From: Martyn White <Martyn.White@arun.gov.uk> **On Behalf Of** Conservation Officer
Sent: 04 April 2025 16:49
To: Planning.Responses <Planning.Responses@arun.gov.uk>
Subject: BR/32/25/PL

BR/32/25/PL

Trevali Lodge 31 Aldwick Road Bognor Regis PO21 2LN

External changes, amendments to fenestrations and re-building the garden wall. This application is in CIL zone 4 (zero rated as other development), may affect the setting of listed buildings and may affect the character and appearance of the Aldwick Road, Bognor conservation area

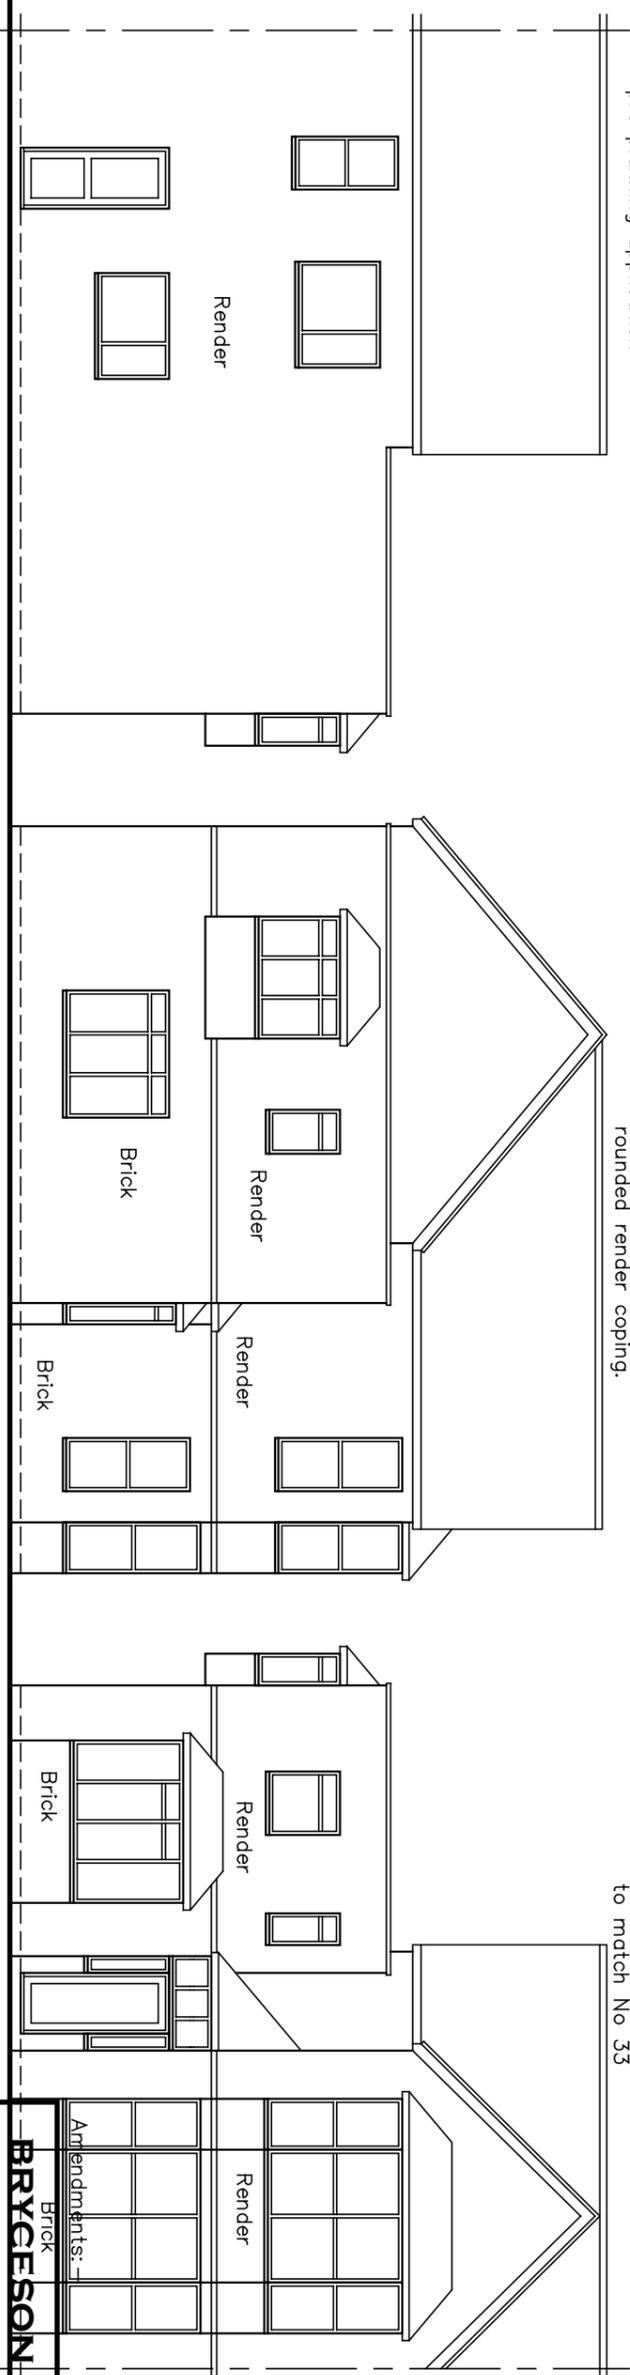
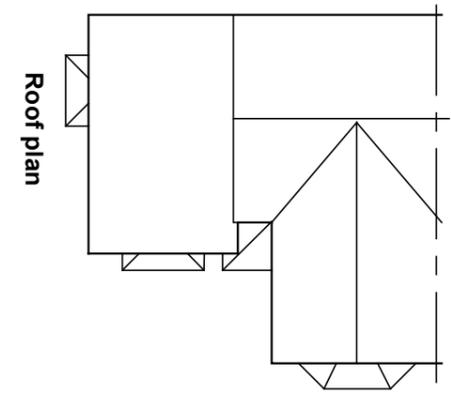
The proposal is for what is described as external changes, amendments to fenestrations and rebuilding the garden wall. It is positive that the external walls of the house will no longer be altered, and that repairs would be undertaken to the existing materials. However, I would be looking to ensure that appropriate and matching materials will be used. Otherwise the replacement bricks could jar and harm the appearance of the building.

The use of UPVC windows is disappointing – it is also not fully clear what they would look like. Would they be fully functional sliding sash windows? I should point out that top hung windows would not be supported. If you are happy with the use of this material, you might want to condition further details of the windows. This will help to ensure that they actually are of a conservation standard.

It is also not clear what the need to rebuild the existing garden wall is. Was it in a poor state of repair? No information has been supplied as part of the application. I have undertaken a site visit, and it is clear that the wall has already been demolished, and I am unable to locate a permission for this action, which is disappointing. This was an attractive flint wall, which was reflective of those in the conservation area and locality. The proposal is for a new wall to be constructed from brick as opposed to flint. If the new wall cannot be constructed using individual flints, then the use of bricks might be acceptable in this instance. It might help to condition a sample of both of the bricks and the wall – in order to ensure that it is of an acceptable standard for the conservation area.

No development shall take place until a sample 1 square meter sample panel of brickwork has been constructed on the site. This section will be inspected by the Local Planning Authority's Conservation Officer and photographic evidence of the sample panel including details of the mortar mix will be submitted to and approved in writing by the Local Planning Authority. Once approved, the work can proceed, and the details so approved will be used within the construction of the development.

Prior to their insertion details of the windows and doors including their design/appearance (including elevation), specification, method of opening, in the form of drawings and sections of an

appropriate scale, shall be submitted to and agreed in writing by the Local Planning Authority before the windows and doors are installed.
